Client	Hawthorn
Project	Portland, ME
Lead Designer	
Production Manager	Jason DiOrazio
Production Staff

Revision #	Sheet	Description of Change	A0.0 Dotted?	Assigned Date	Responsible Staff	Completion Date
6	A0.0	Added revision 6 to title block	Y			
	A0.1	Elevator Equipment room moved to rear of building. Wall type revised in Hall 148.				
		Rear doors revised to storefronts.				
		Standpipe cabinet added in core. Standpipe note added to Legend.				
	A0.2	Tv room windows removed and revised.				
		Standpipe cabinet added in core. Standpipe note added to Legend.				
	A0.3	Unit 323 revised.				
		Standpipe cabinet added in core. Standpipe note added to Legend.				
	A0.4	Standpipe cabinet added in core. Standpipe note added to Legend.				
	A1.1	Carports added. Parking spaces revised.				
	A1.7	Dtl 1 removed.				
	A1.8	Dtl 5 added.				
	A1.9	Dtl 7 added. Zip system note added and zip added to details.				
	A2.1	Elevator Equipment room moved to rear of building. Wall type revised in Hall 148.				
		Rear doors revised to storefronts.

A5.4

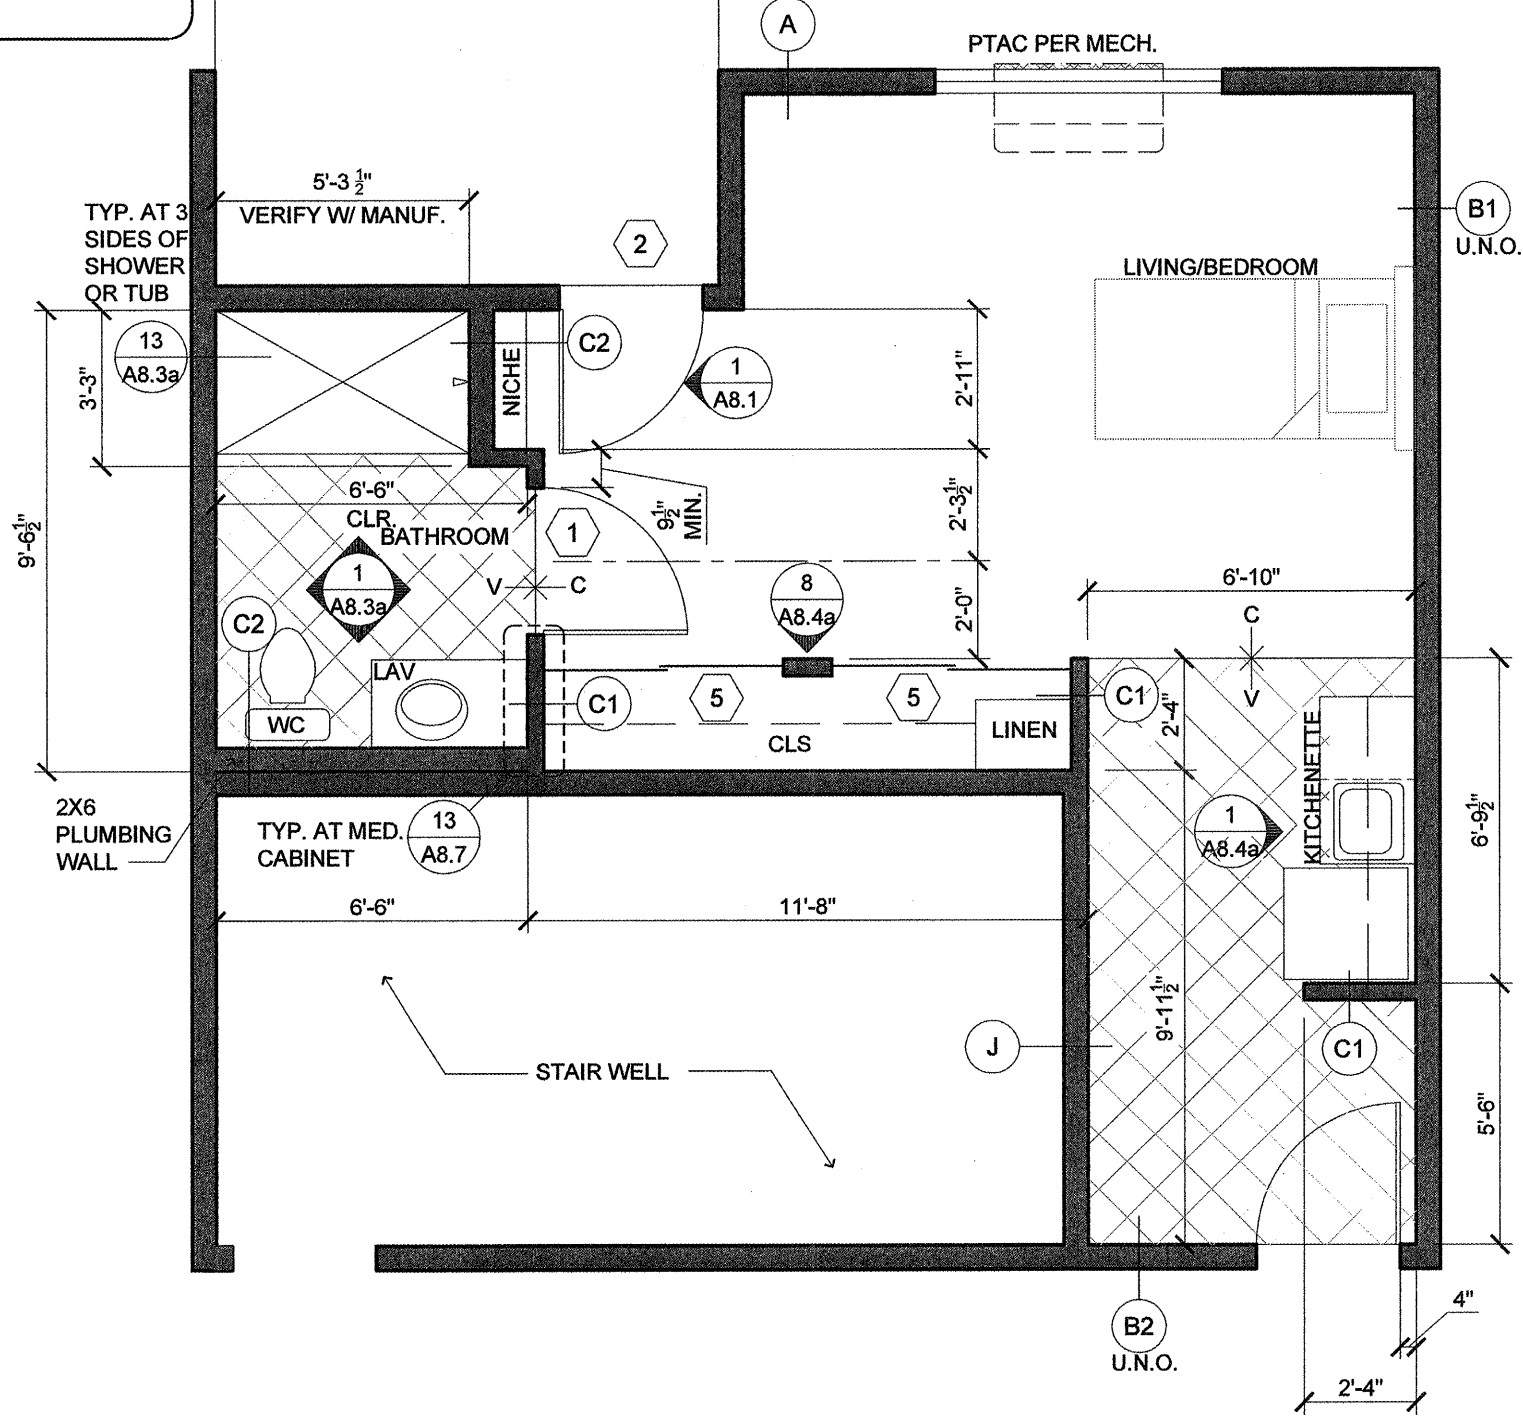
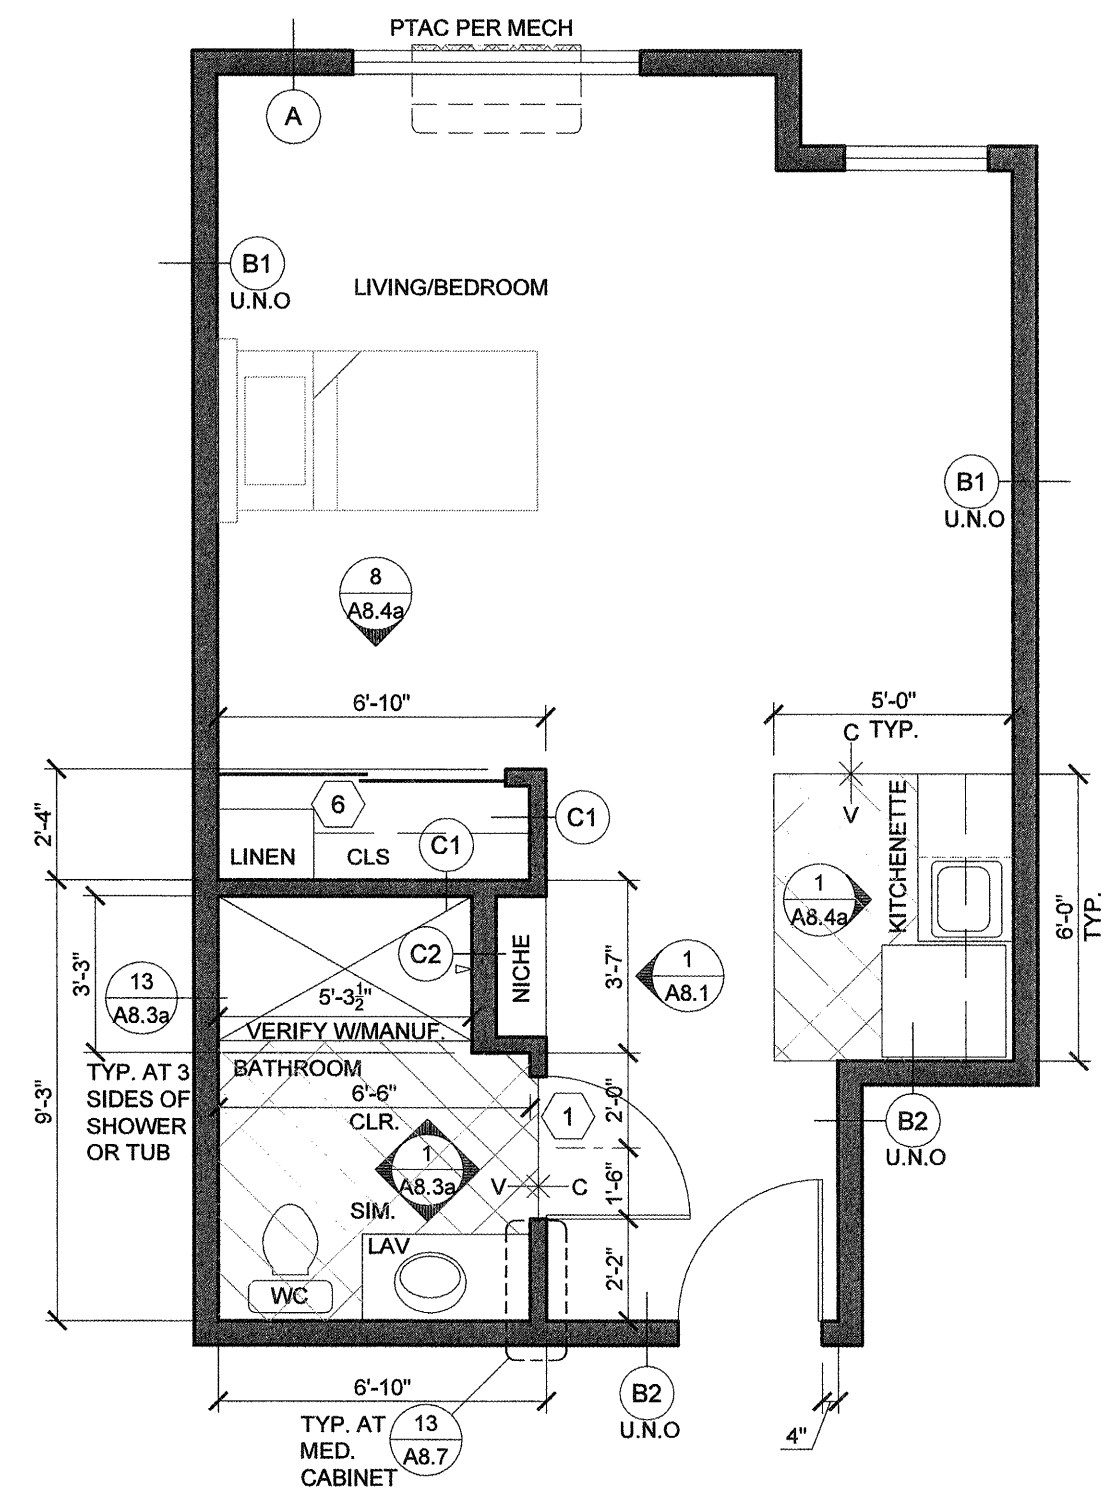
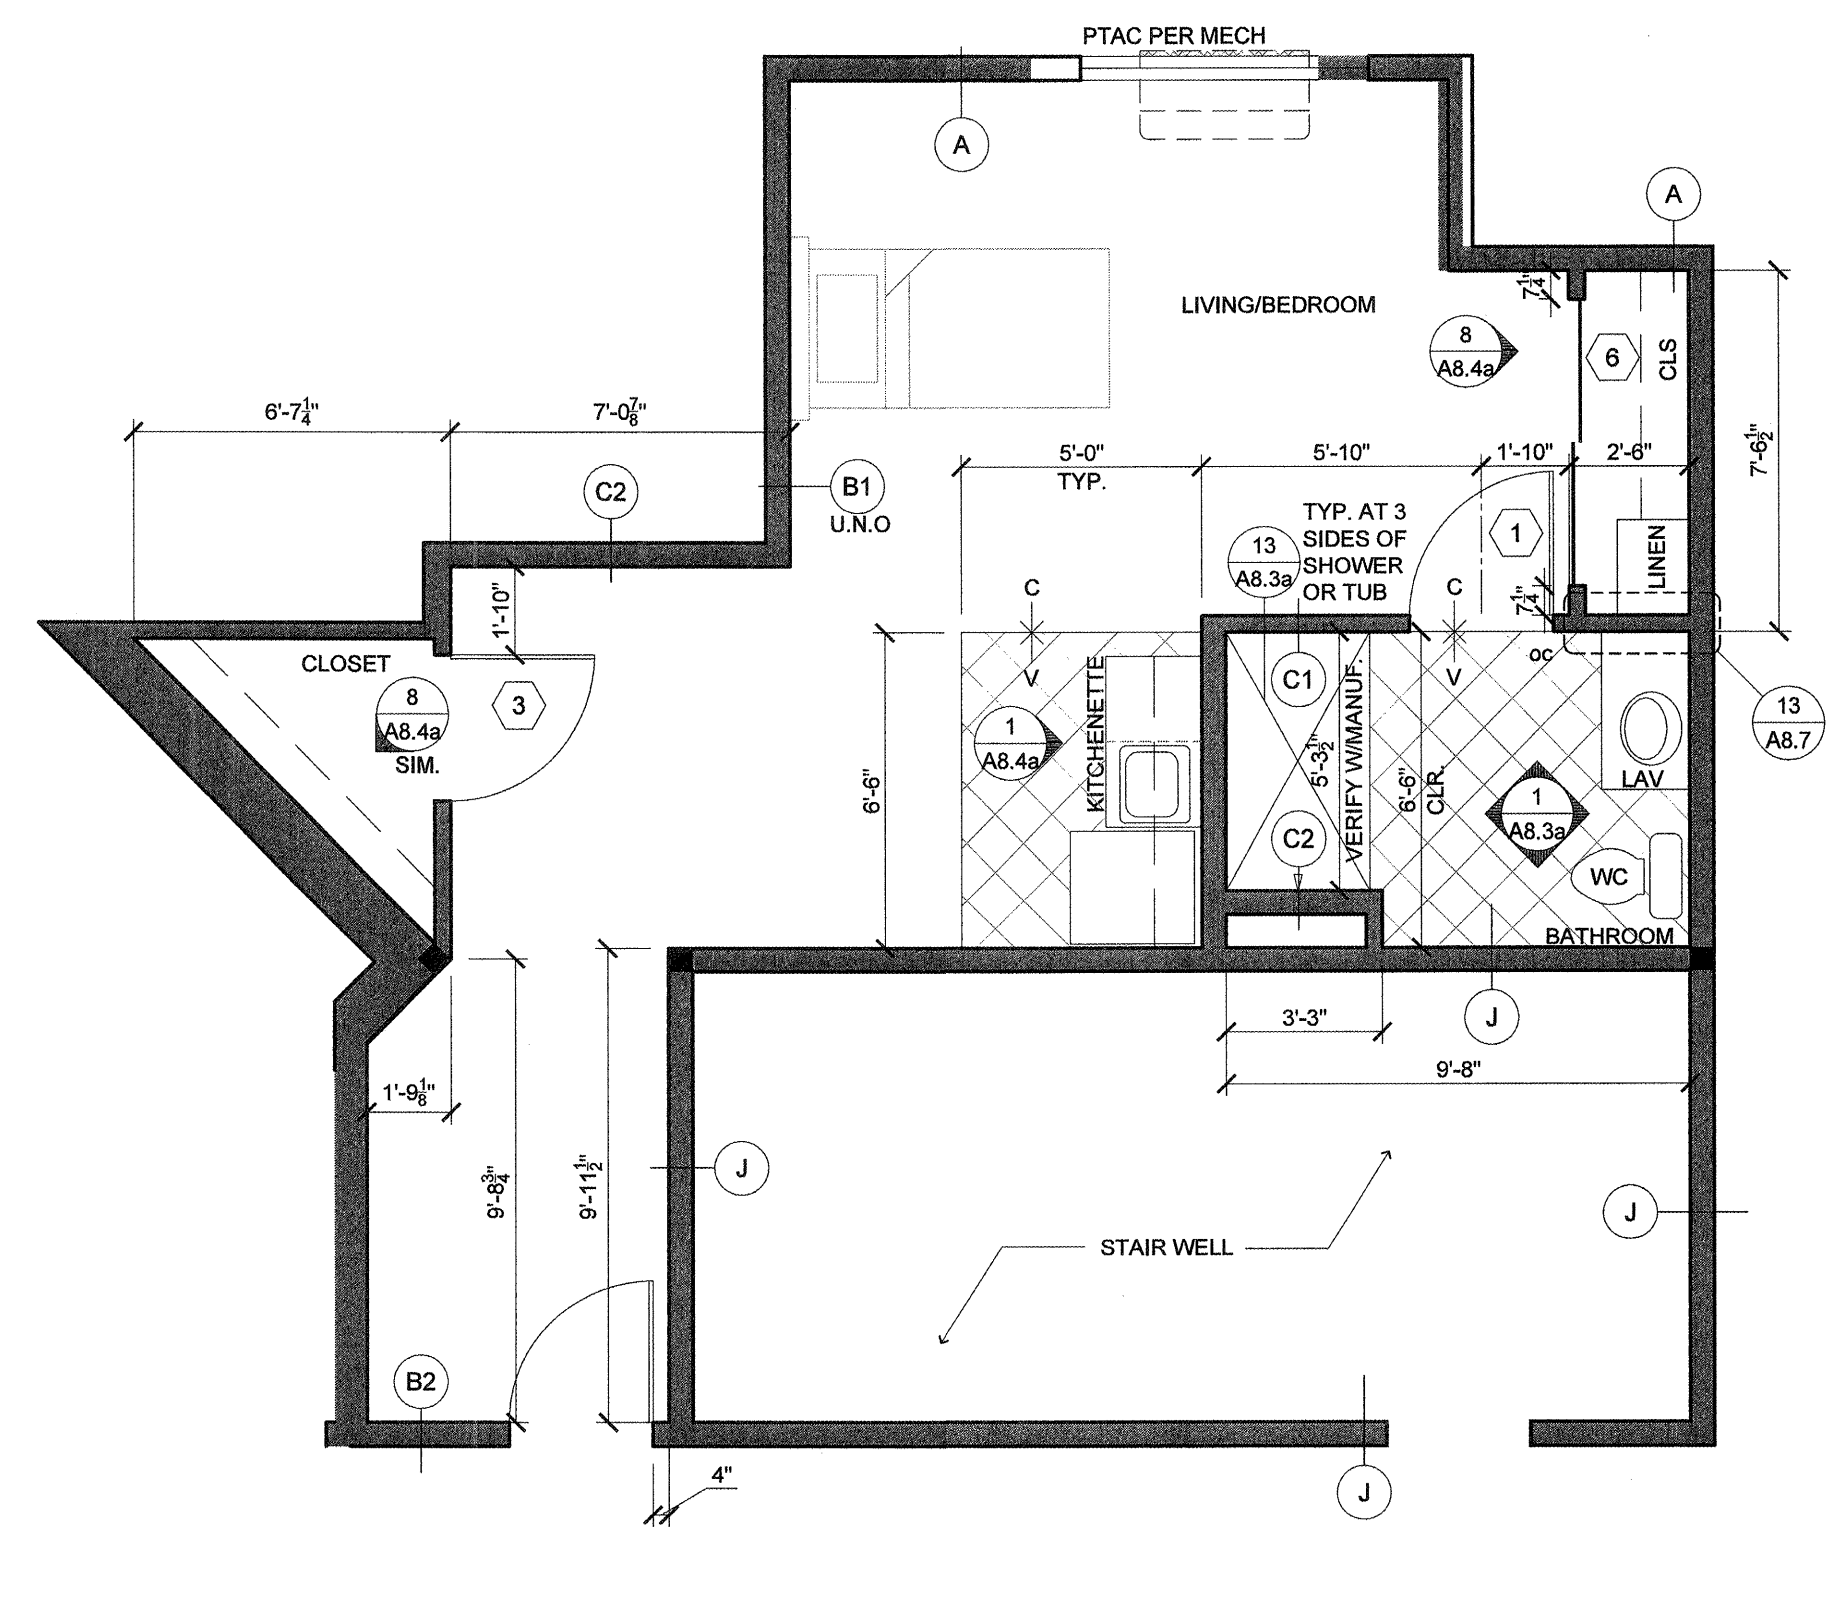
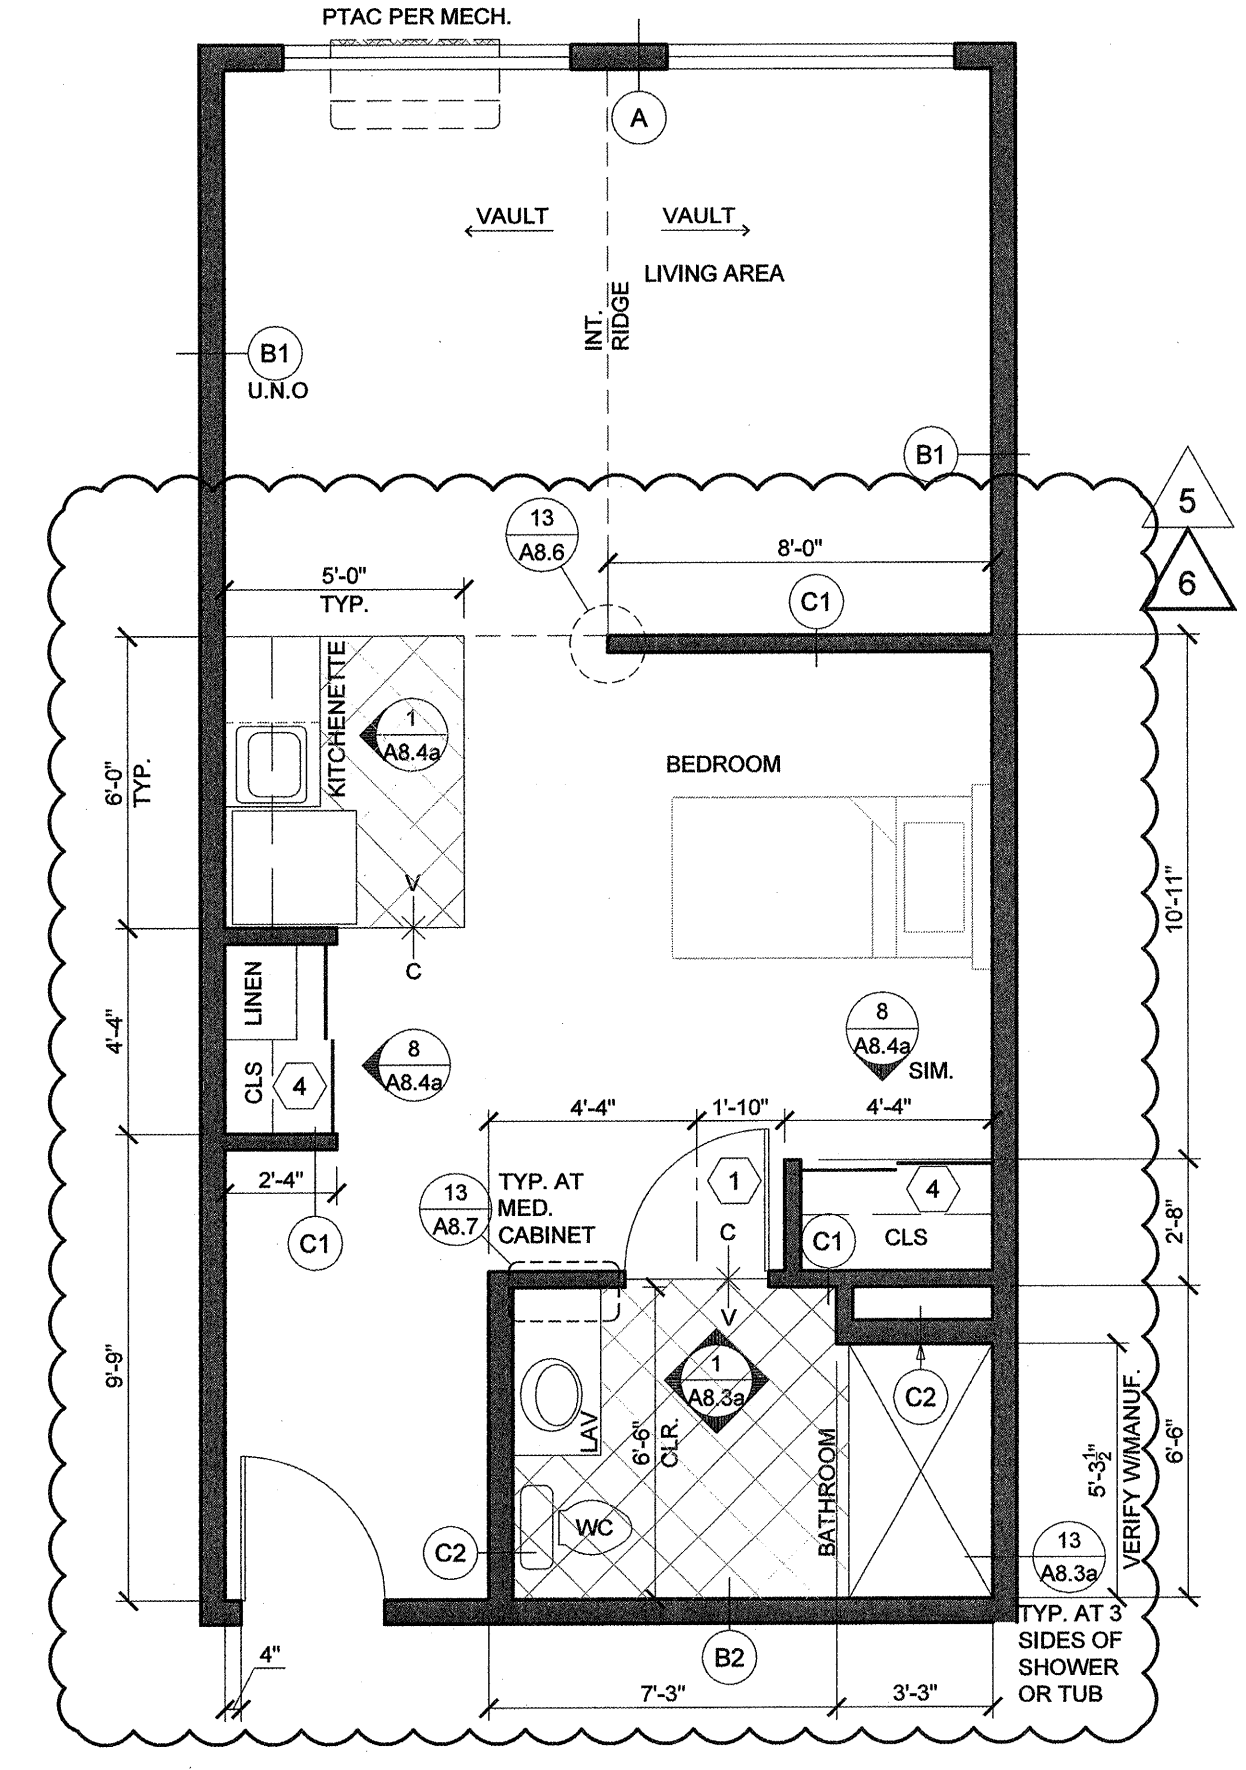
A4.6	Callout added. Vault added at B4.				
A4.7	Dtl 7 Reading room revised. Dtl 2 updated per new ceiling at Activity room				
A4.8	Dtl 8 and 12 soffit heights revised.				
A4.9	Dtl 3 soffit revised. Dtl 10 revised.				
A5.1	Dtl 8 note removed.				
A5.3	Dtl 2 revised to remove Elevator Equipment room.				
A5.4	Dtls 4 and 6 revised.				
A5.5	Dtl 6 2x8 walls added and dimmensions revised.				
A5.7	Dtl 6 revised.				
A5.9	Dtl 6 revised.				
A5.10	Dtls 2 and 4 2x8 walls added.				
A6.0a	Insulation values added and callouts revised. Reading room fireplace revised. Deck floor slope revised.				
A6.0b	Insulation values added and callouts revised. Rafter revised outside of Dining. Ceiling information updated at Activity room				
A6.0c	Insulation values added and callouts revised. Rafter revised outside of Dining in Section C and E.				
A6.1a	Insulation values added and callouts revised. Catwalk revised. Staff room updated.
